M60/M62/M66 Simister Island Interchange Project

The Examining Authority's (ExA) Consultation draft Development Consent Order (dDCO)

Schedule of ExA's recommended amendments to the applicant's dDCO submitted at Deadline 5 [REP5-005]

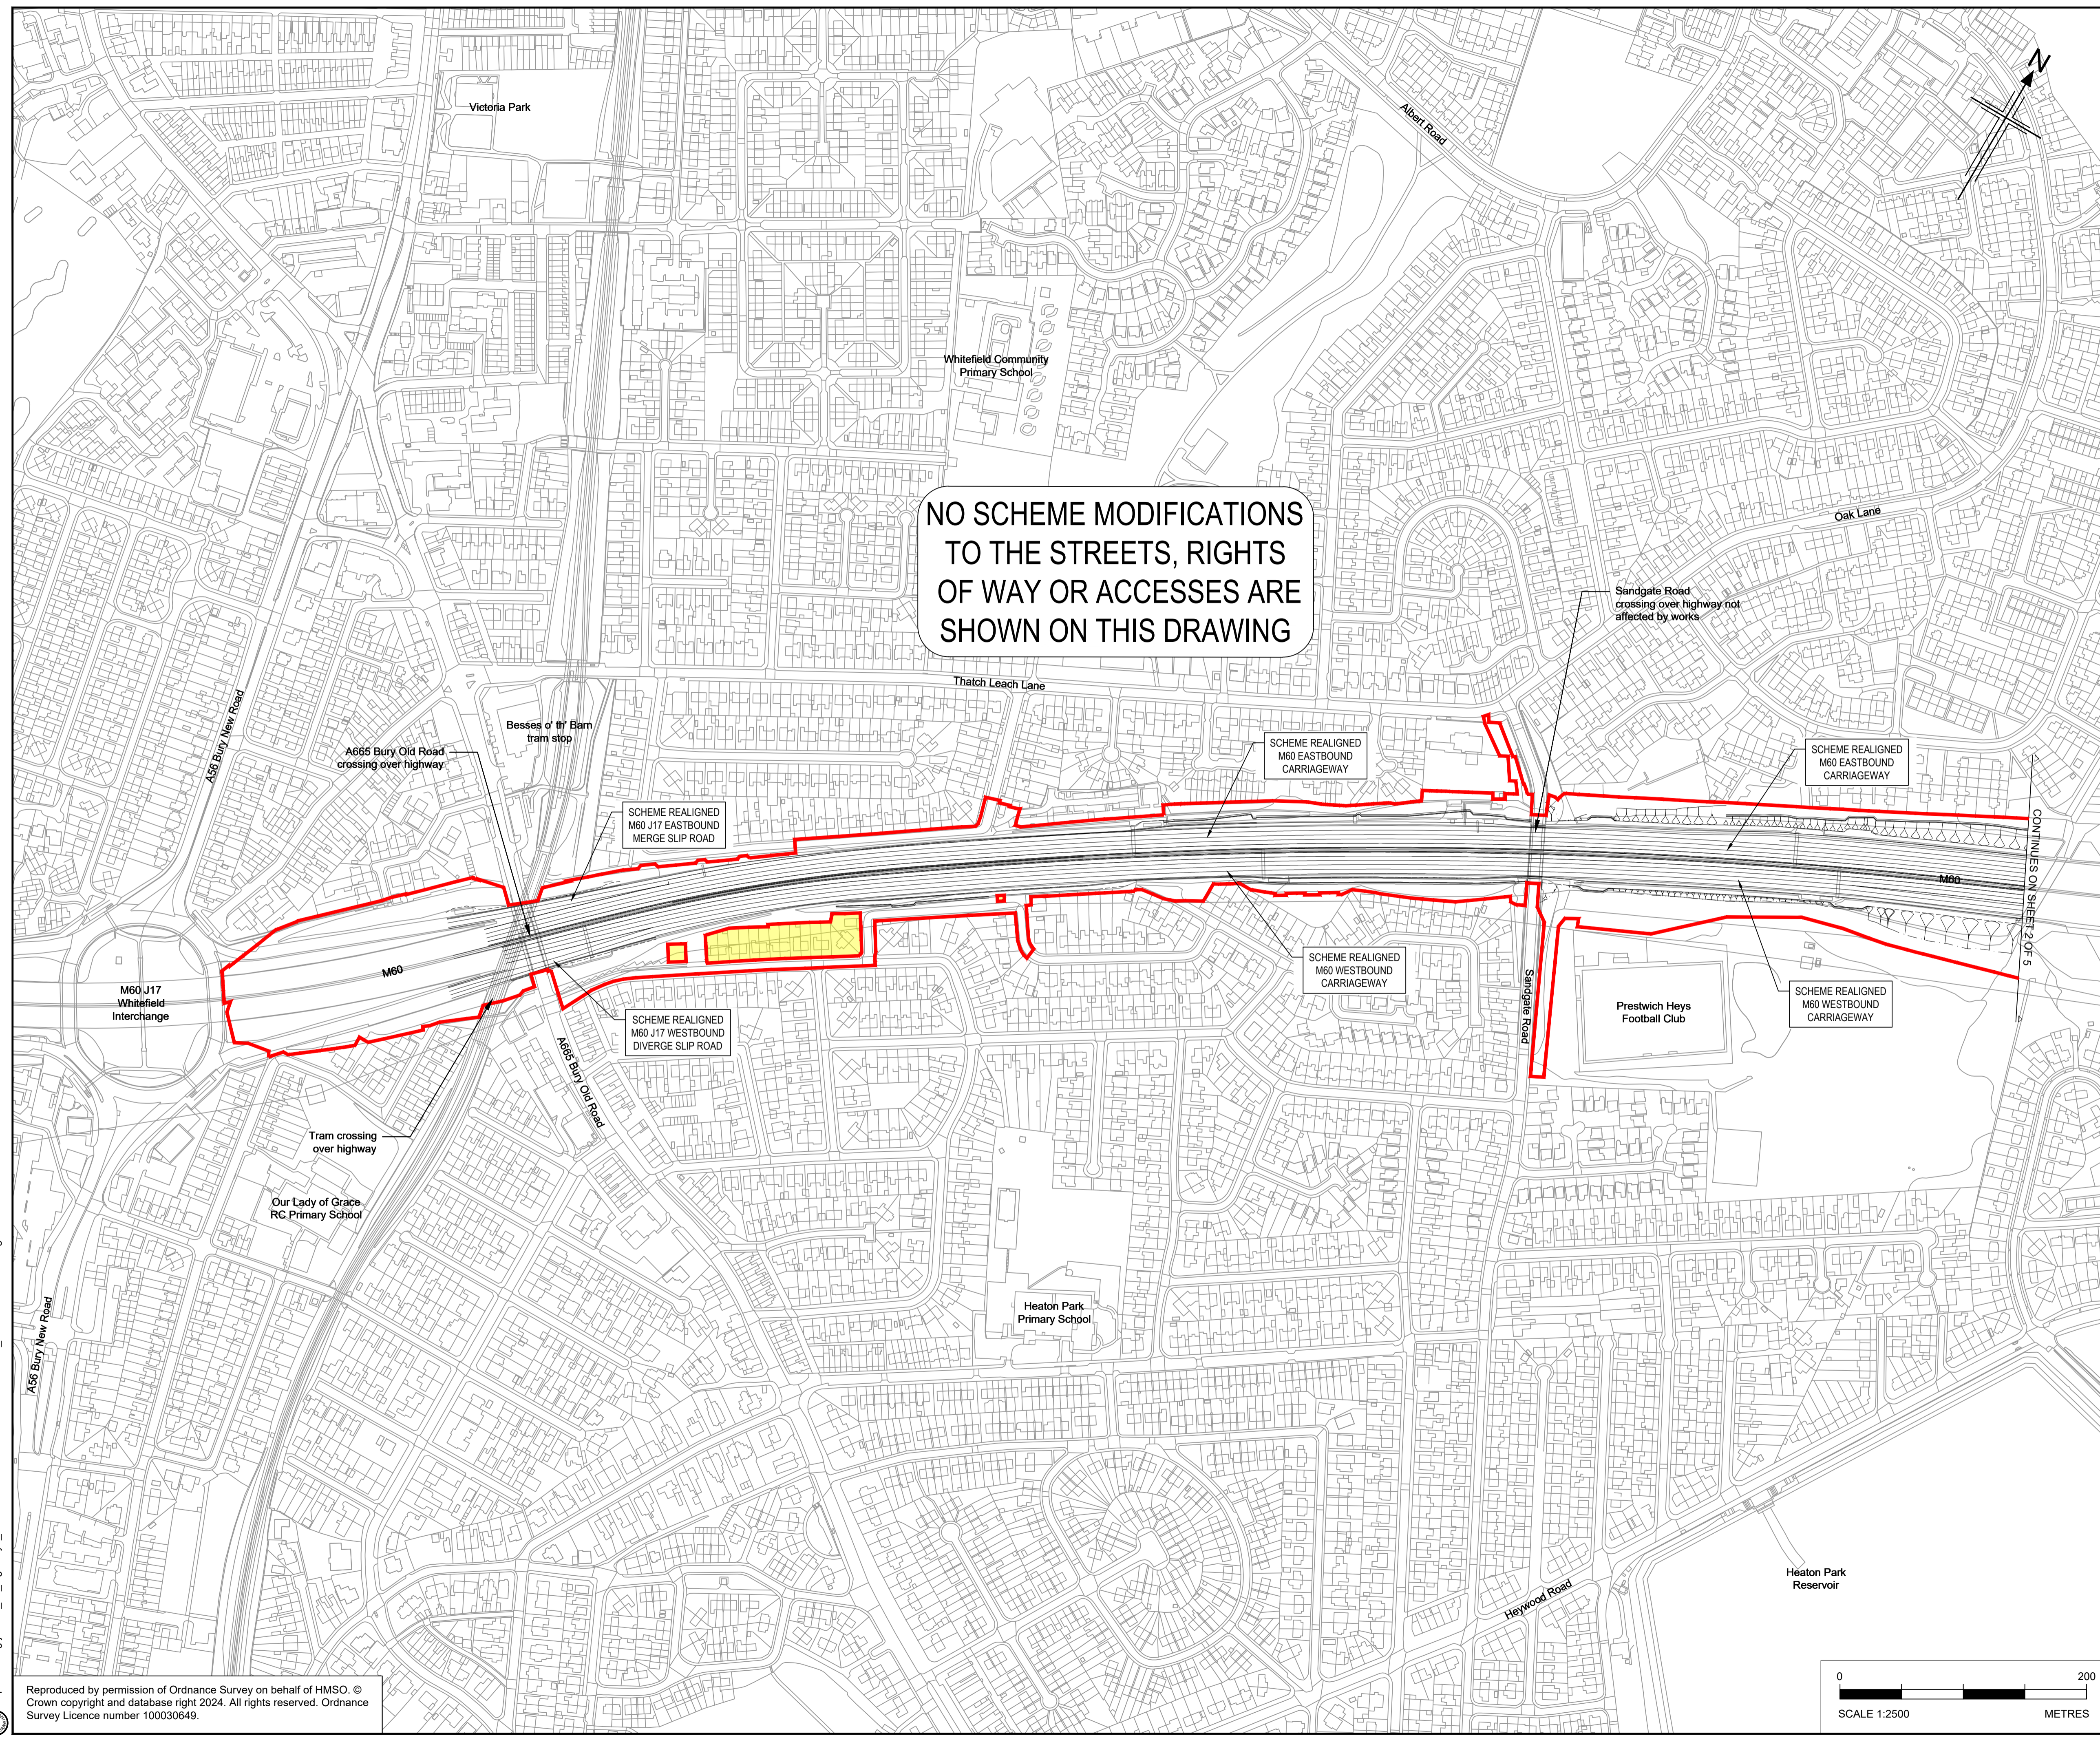
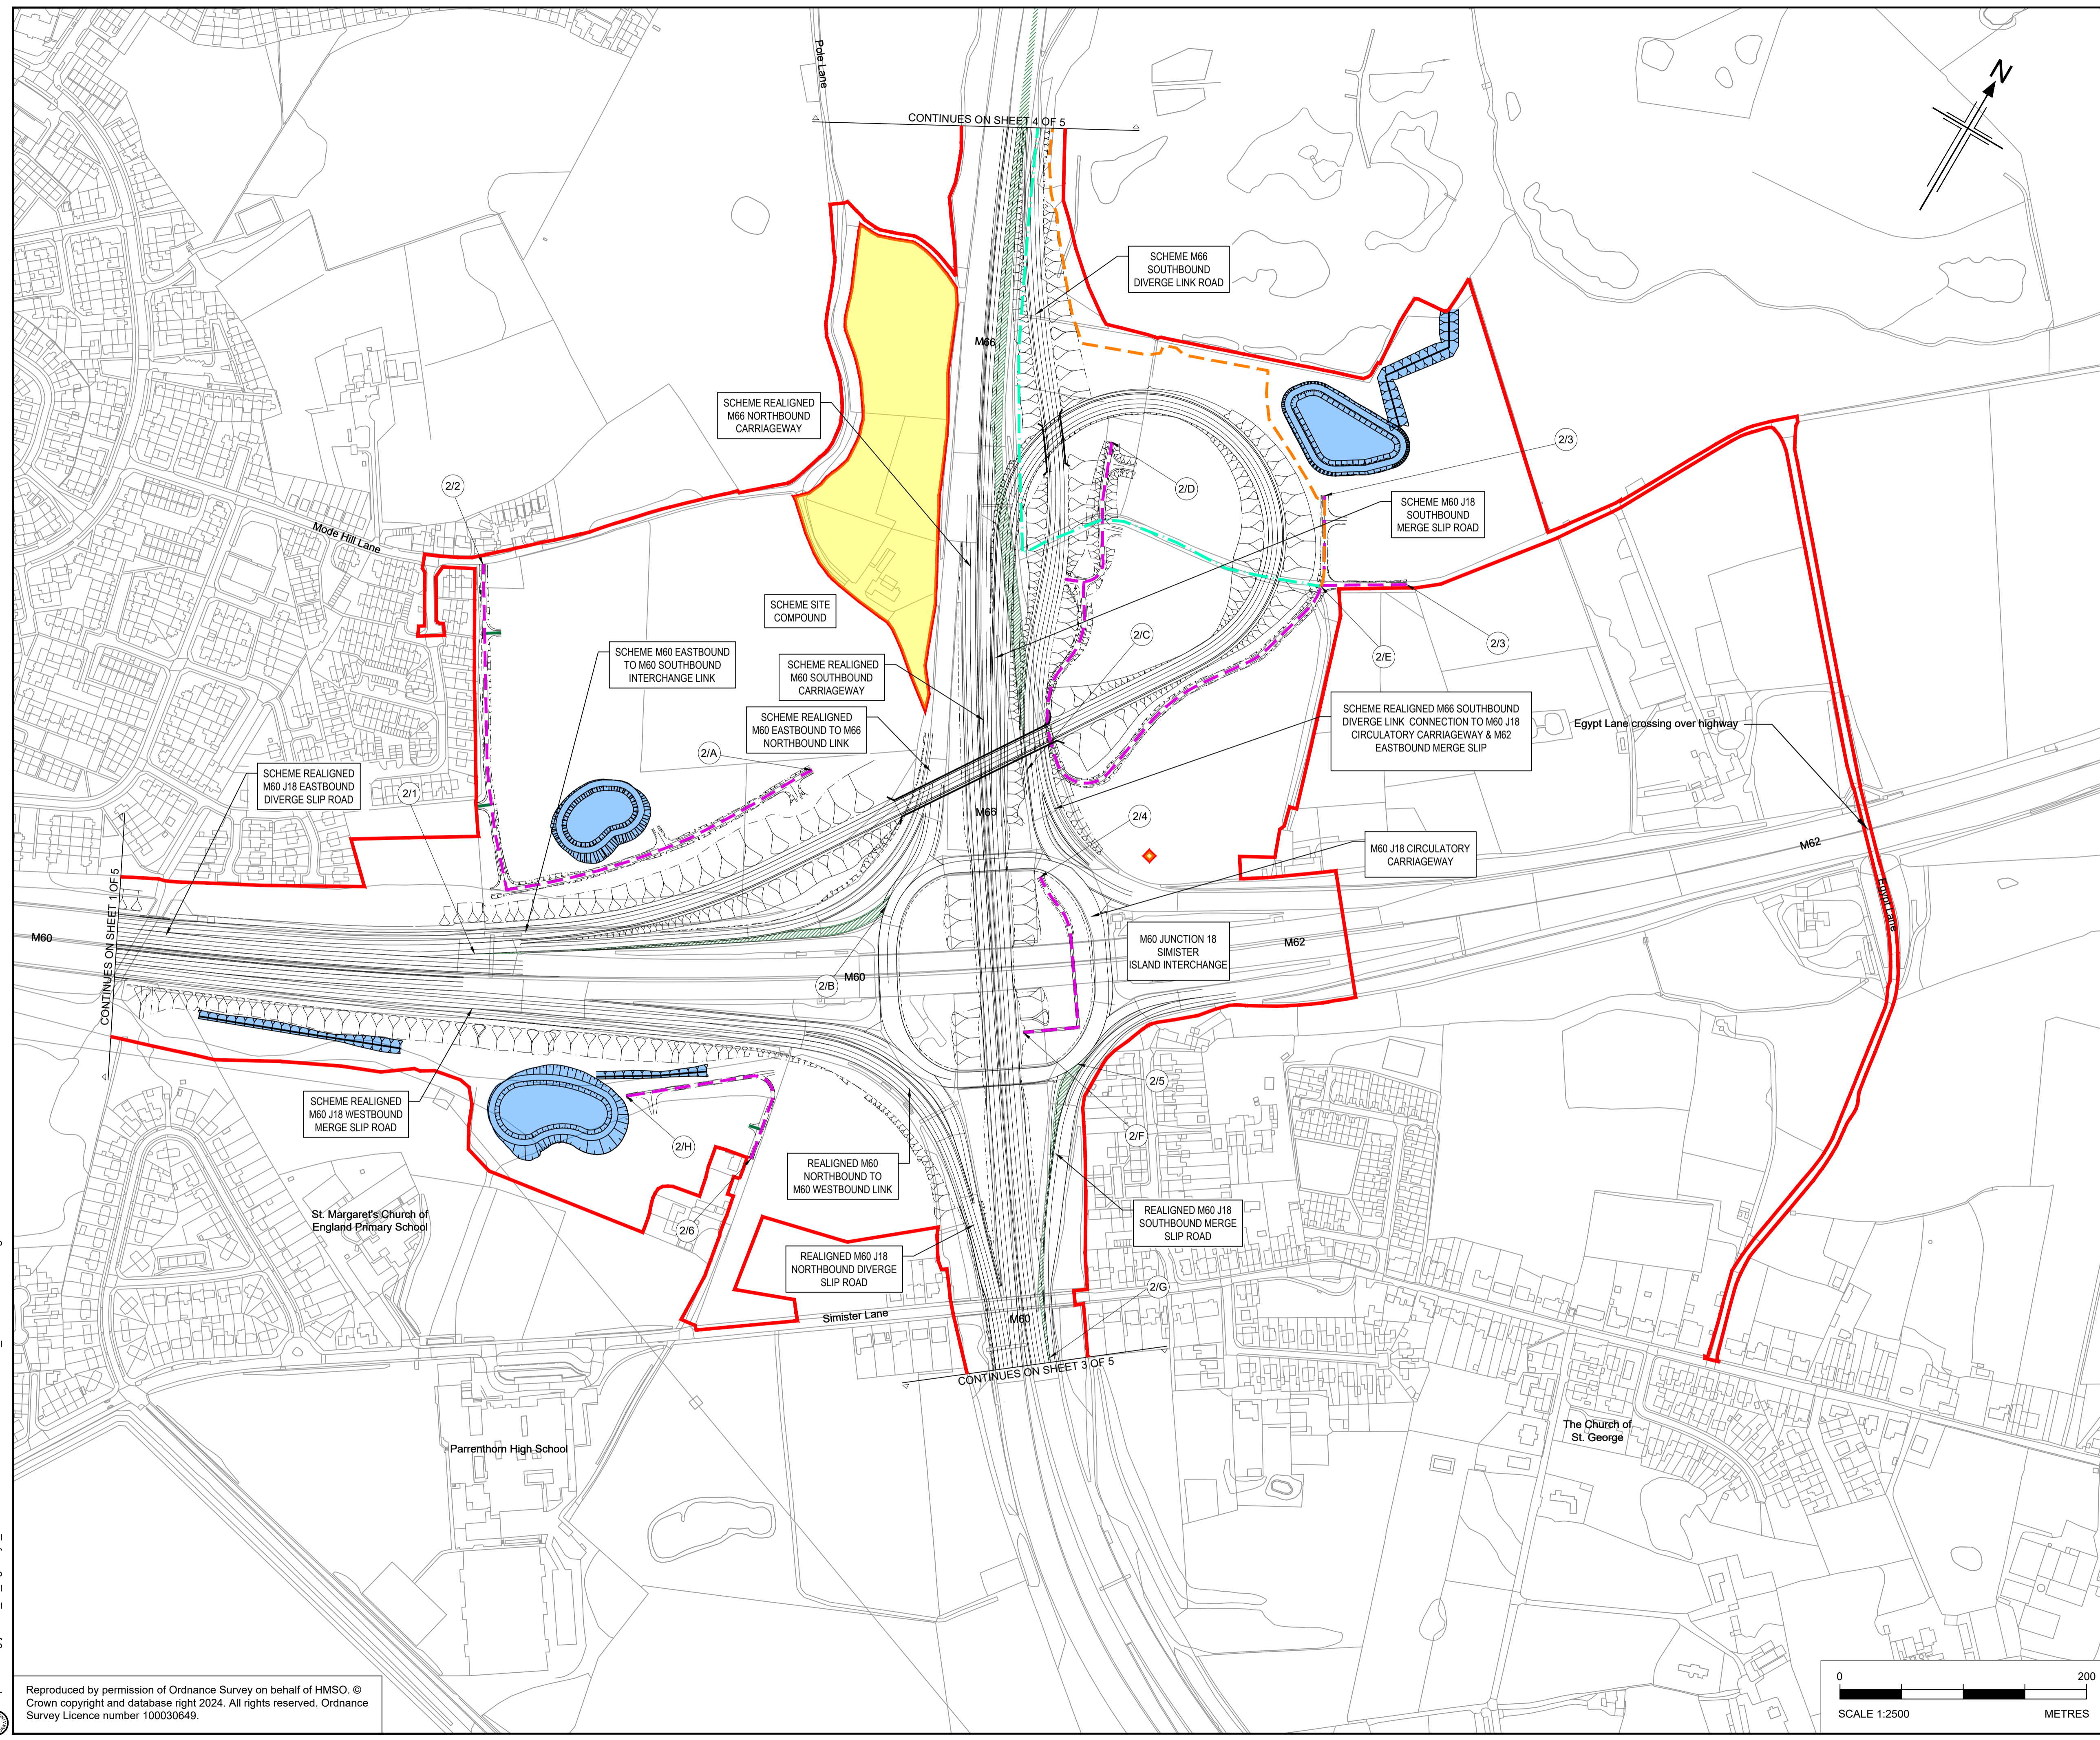
5.	13. Classification of roads etc.	(4) The private means of access specified in column (2) of Part 3 (private means of access) of Schedule 3 and identified on the	(4) The maintenance accesses and private means of accesses specified in column (2) of Part 3 (private means of access) of	To improve precision by clarifying that the article also includes the 'maintenance accesses' as identified on the Streets, Rights of Way & Access

No.	Article / Schedule	Text as set out in the draft DCO [REP5-005]	ExA's Recommended Amendment	Reason and Notes
		streets, rights of way and access plans are to be constructed by the undertaker in the specified locations and open for use from the date on which the authorised development is open for traffic.	Schedule 3 and identified on the streets, rights of way and access plans are to be constructed by the undertaker in the specified locations and open for use from the date on which the authorised development is open for traffic.	Plans [APP-008], noting the applicant's response to ISH1 Action Point (AP) 8 [REP1-024] that the article is intended to cover both the both the maintenance access tracks listed in Schedule 3, Part 4 and the private means of access.
